**EIS comments - Sydney Metro City and Southwest (Sydenham to Bankstown)**

**Ref: SSI 8256**

Figure 98: Marrickville Station – indicative layout of key design elements

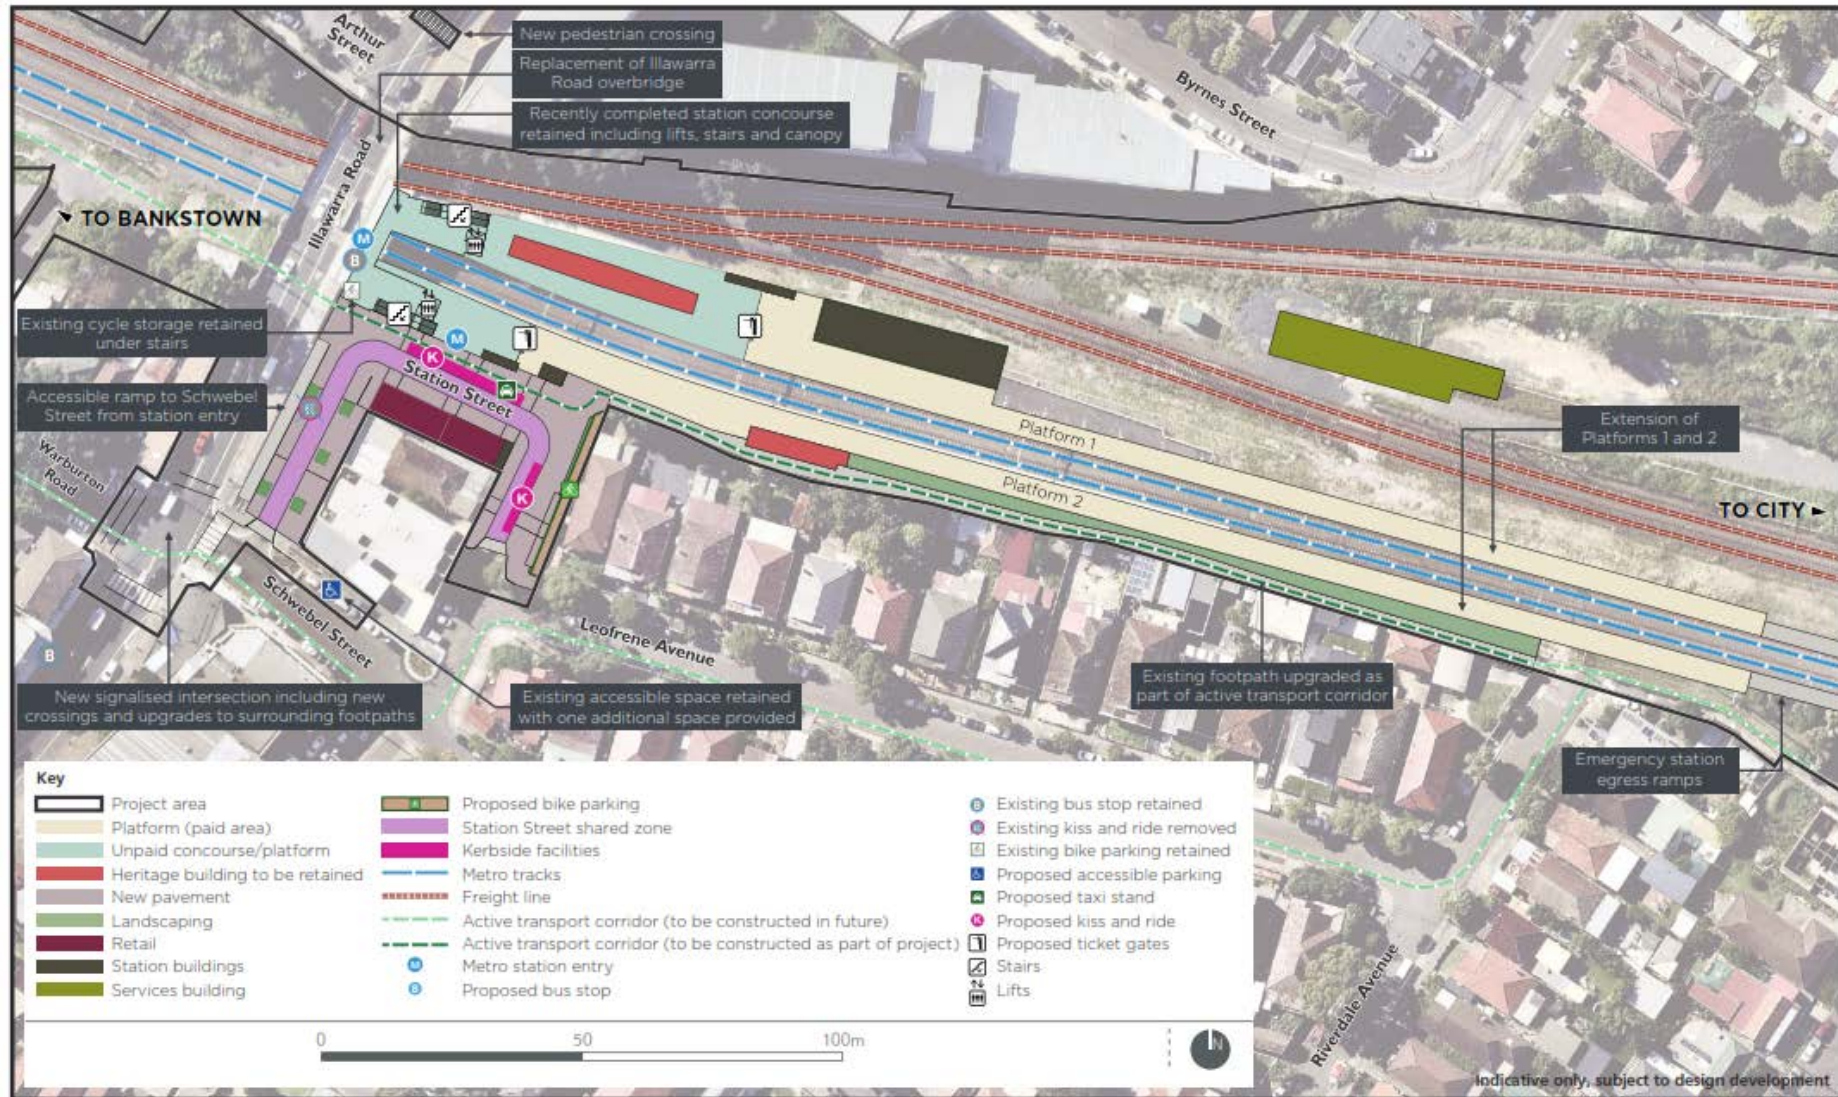
The following should be considered due to the challenging existing conditions at Marrickville station:

- Confirmation of ownership for the proposed Detention basin.
- The review of discharges to the Malakoff tunnel in minor flood events.
- The proposal to pipe additional stormwater flows from the southern side of Marrickville Station to the northern side of the railway line will have a negative impact which will cause flooding to the low-lying properties near the intersection of Byrnes and O'Hara Streets.
- The overall flood management plan should investigate a controlled overland flow path along the southern side of the railway line at Station Street.
- Water quality improvement measures should be incorporated into the design of the basin.
